**MODIFICATION REQUEST APPLICATIONS FOR CONCEPT PLAN
MP09_0216 AND PROJECT APPLICATION MP09_219
Shepherds Bay Redevelopment**

Shepherds Bay Redevelopment

Modification request for Concept Plan MP 09_216
and Project Application MP09_219
Submission from City of Ryde Council

1 BELMORE STREET ELEVATION
A-152/13 1 : 200

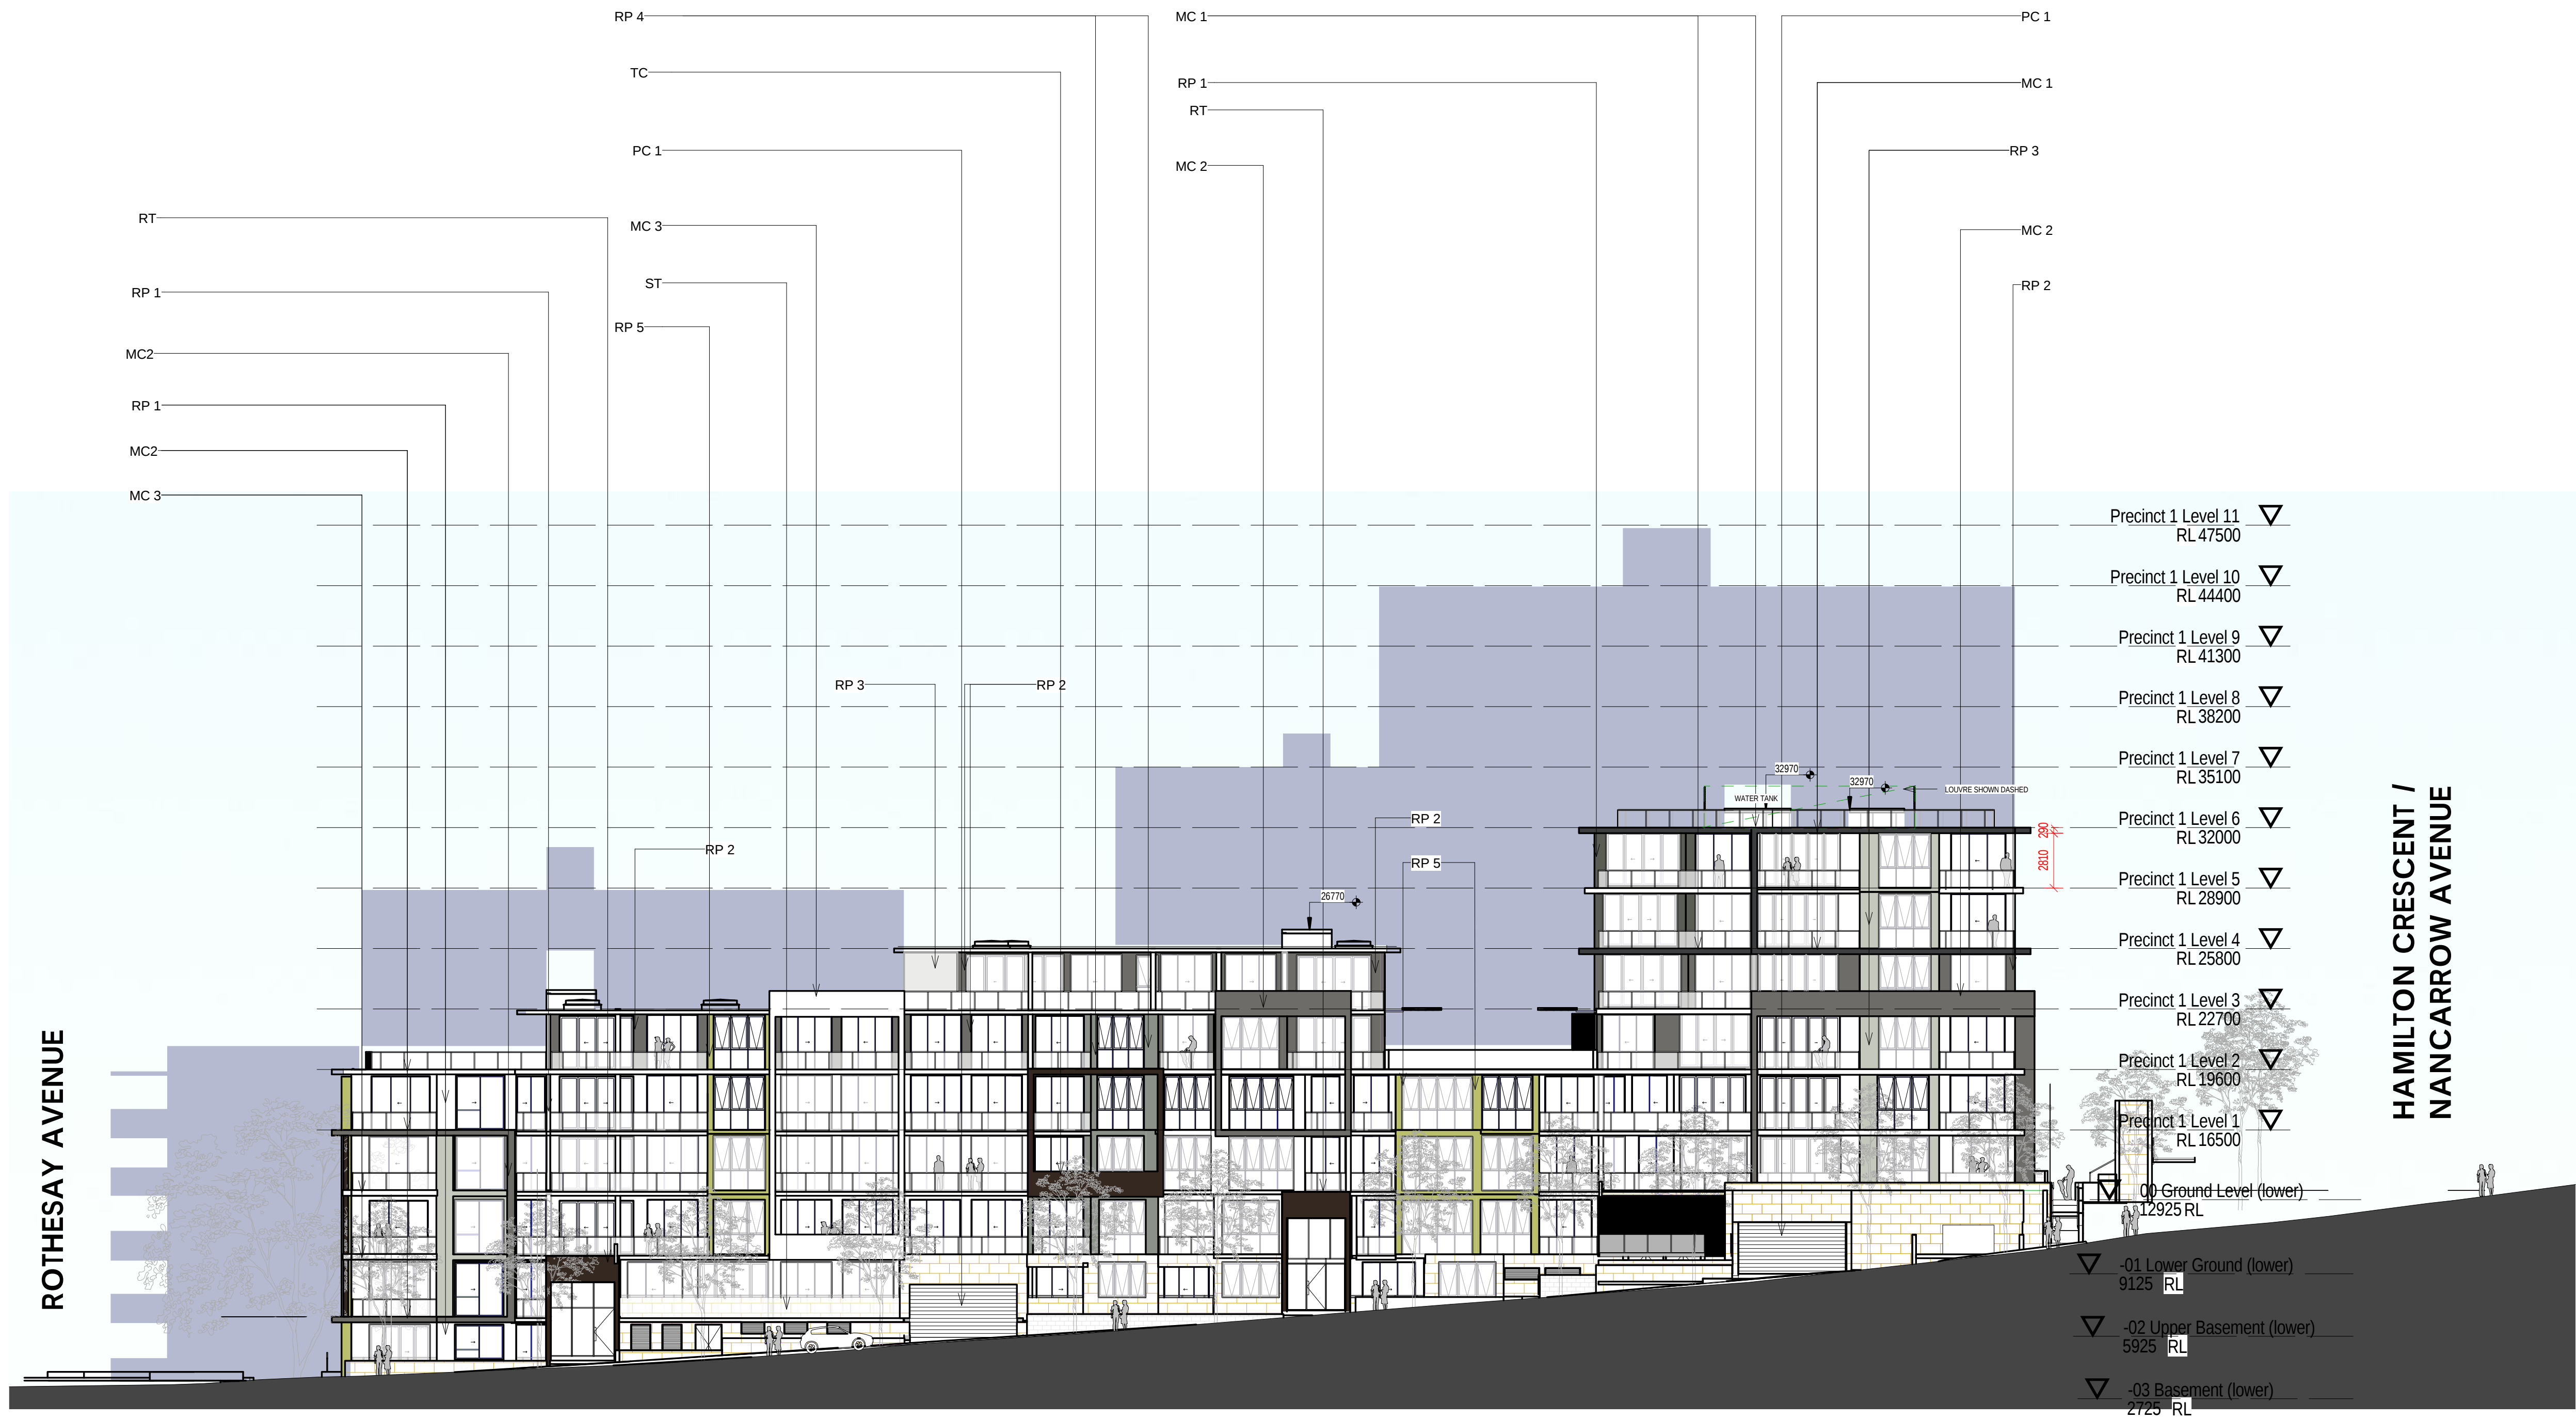
In addition to the above, it should be noted that the addressing of the project application to the surrounding public domain and the presentation of blank facades are the result of insufficient information being provided at the assessment stage. Council had raised this issue previously, but was disregarded by the proponent and the Department. The proposed

design solutions and amendments in Stage 1 has resulted in a series of design, public domain and amenity issues that are not supported by Council.

1 NEW FORESHORE LINK ELEVATION
 A-154/14 1:200

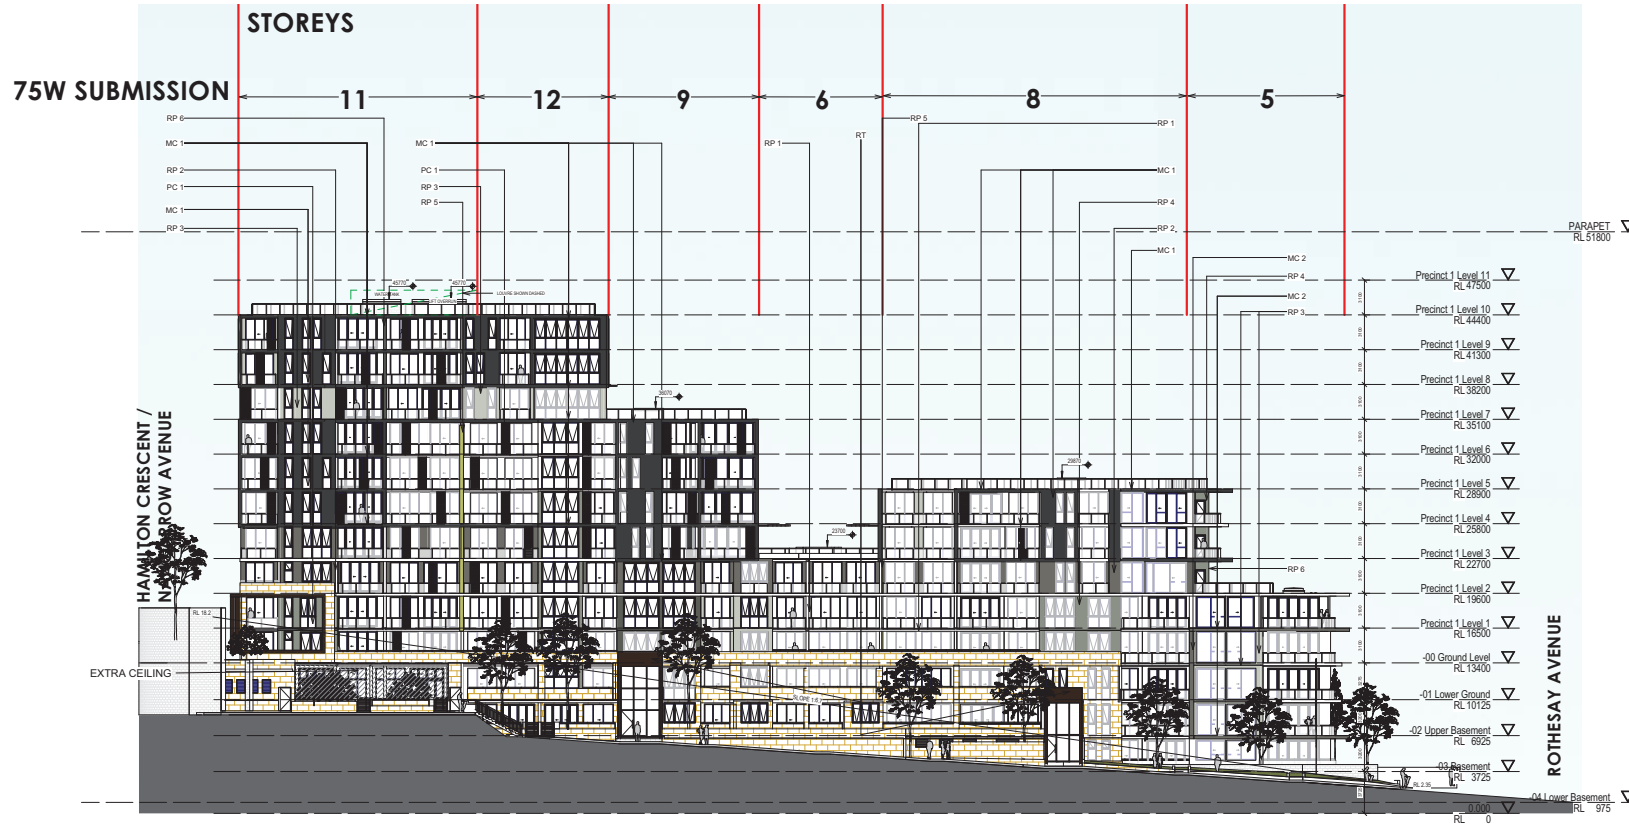
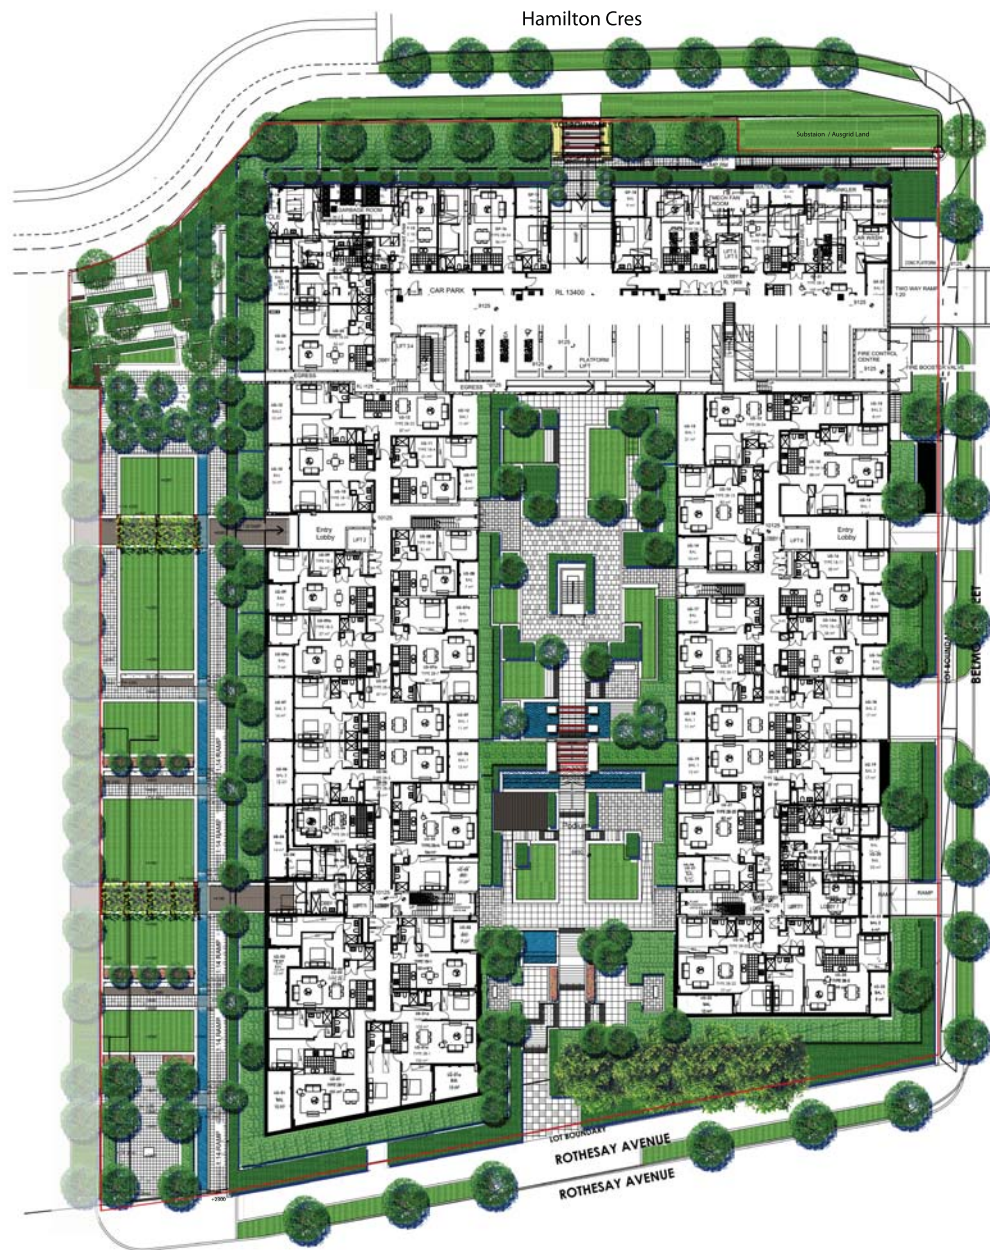
With regards to Stage 1, Council has identified significant concerns with the proposed amendment as this is achieved through the lowering and regrading of the Foreshore Link. This is discussed in depth within the *Project Application* part of this submission. It should be noted by the Department that the adoption of the design for the Foreshore Link will mean that the Central Spine connection between Rothesay and Nancarrow will need to be fully accessible as per Condition 16 of the Concept Approval. Condition 16 provides:
